Planning Services

Arun District Council

OBJECTION — Application WA/68/26/PL: Construction of a single dwelling, with garage outbuilding and associated works, The Greenway, West Walberton Lane, Walberton BN18 0QS (resubmission of withdrawn WA/33/26/PL)

**Land north of The Green Way
Appendix 5 - development proposal plan**

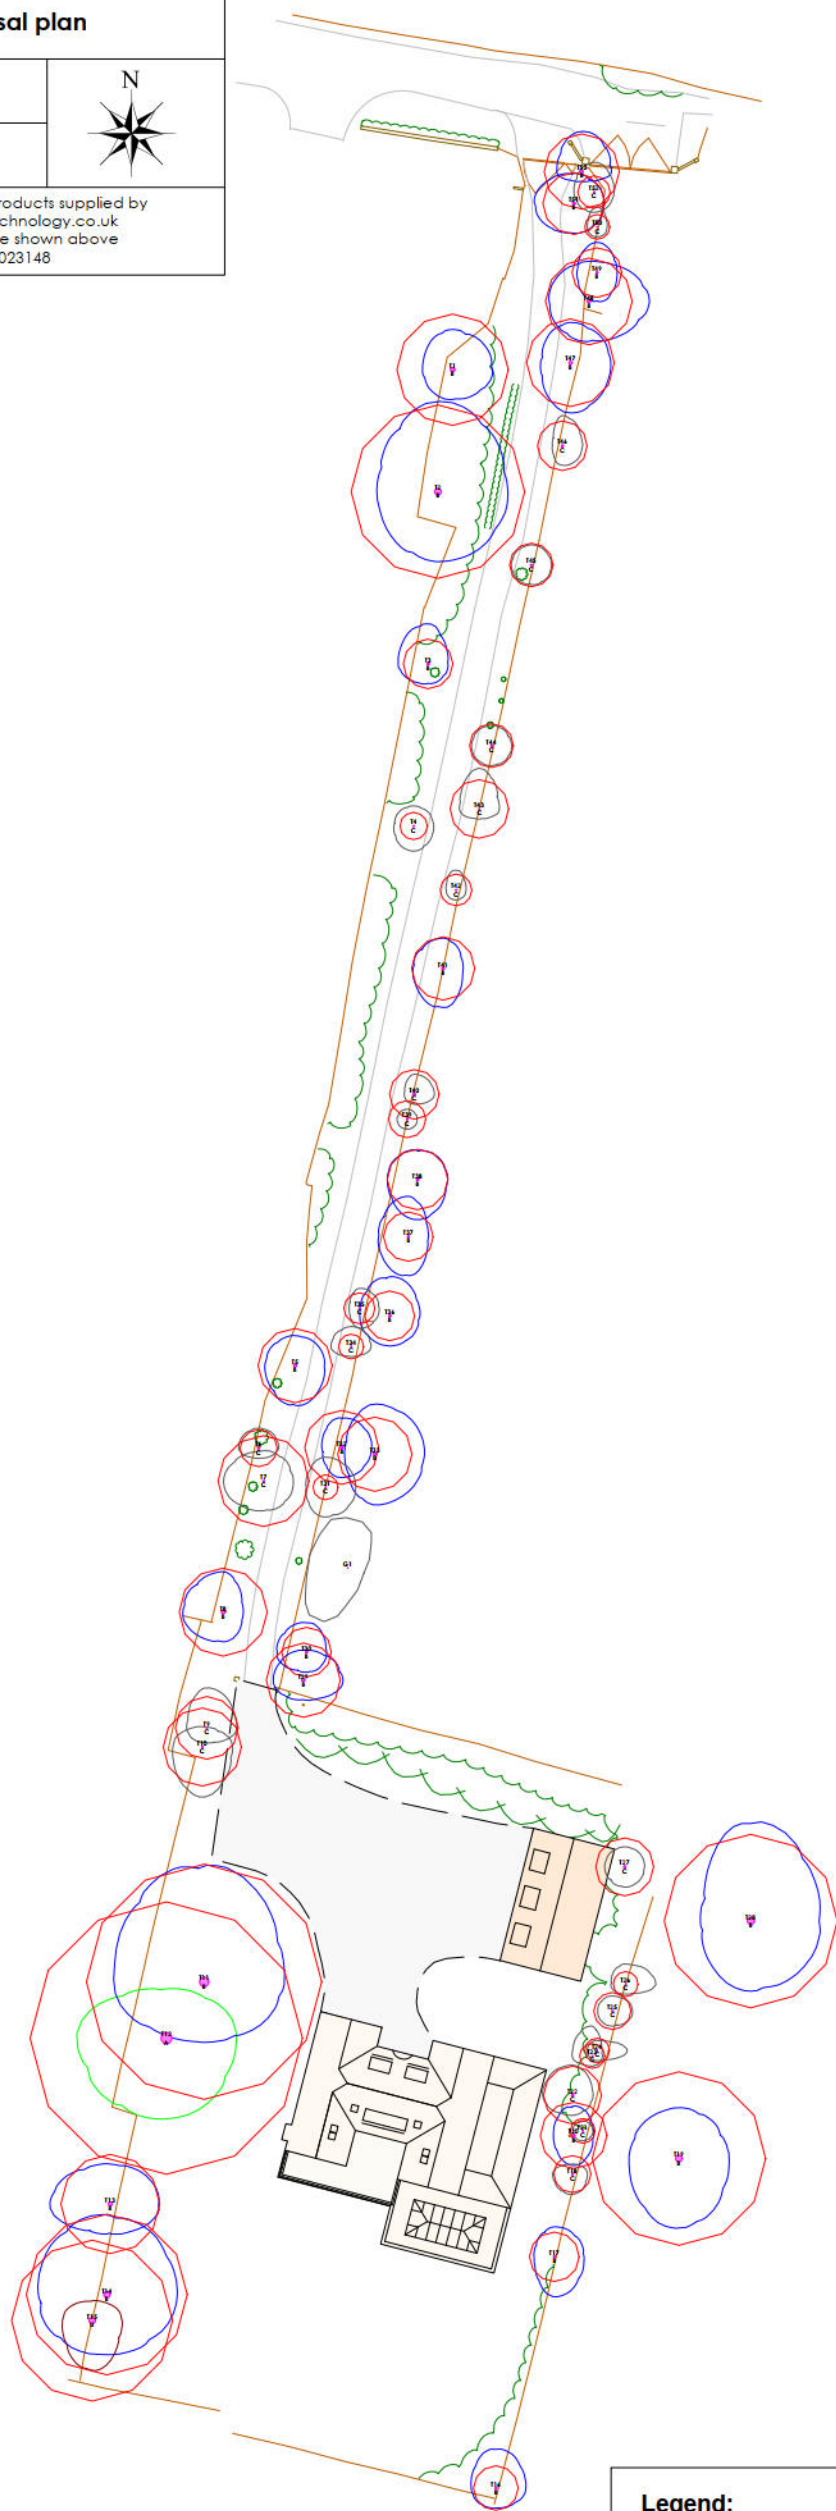
Comment to be passed to Trees Officer Jonathan Best , please: Two Tree Preservation Orders affect the site and its access. The widened track , the nominal root protection areas of several retained trees; the applicant's own arboriculturist concedes that **actual rooting patterns "will be far more irregular" than the plotted RPAs**. The same surface is simultaneously relied upon for storm-water management (section 4 above). In addition, placing a dwelling of this scale close to retained protected oaks creates predictable post-occupation pressure for pruning and felling — a recognised harm in its own right, and one to which this site's recent history (the 2023/4 clearance) lends particular weight.
